12. **Project# 1010203**
15DRB-70040 SKETCH PLAT REVIEW
AND COMMENT

**CITY OF ALBUQUERQUE
PLANNING DEPARTMENT
February 11, 2015
DRB Comments**

PROJECT # 1010203 APPLICATION # 15-700040

RE: Lot 11 & 12, Block 6, Albright – Moore Addition

PLAT
 OF
LOT 12A, BLOCK 6,
 (BEING A REPLAT OF LOTS 11 AND 12)
ALBRIGHT-MOORE ADDITION
 WITHIN
 TOWN OF ALBUQUERQUE GRANT
 PROJECTED SECTION 17, TOWNSHIP 10 NORTH, RANGE 3 EAST,
 NEW MEXICO PRINCIPAL MERIDIAN
 CITY OF ALBUQUERQUE
 BERNALILLO COUNTY, NEW MEXICO
 JANUARY 2015

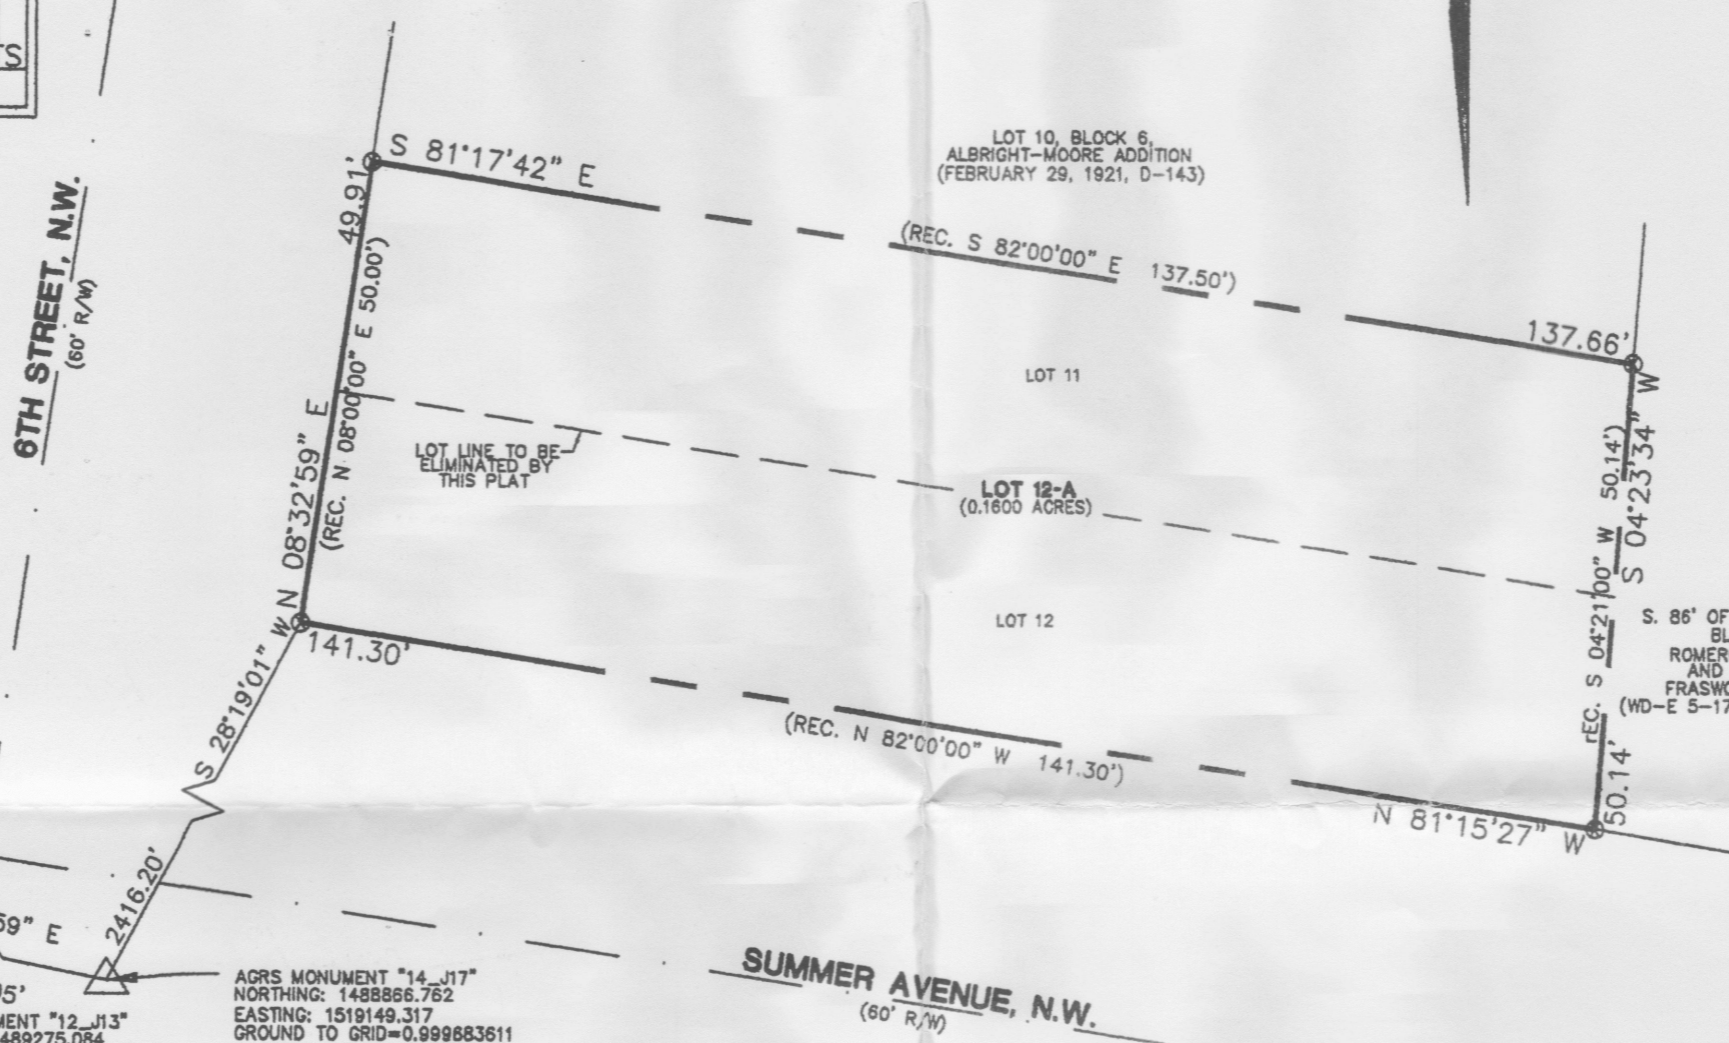
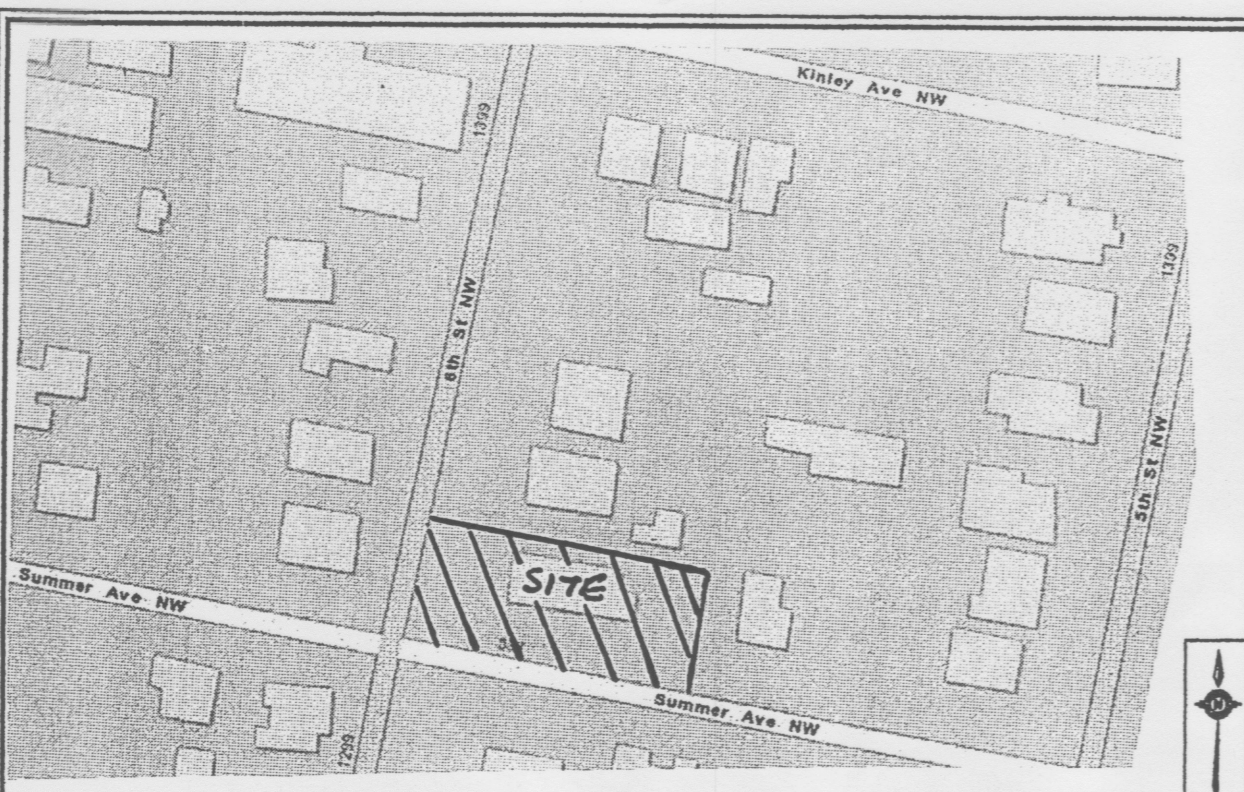
Delete note 8 as zoning could change in the future.
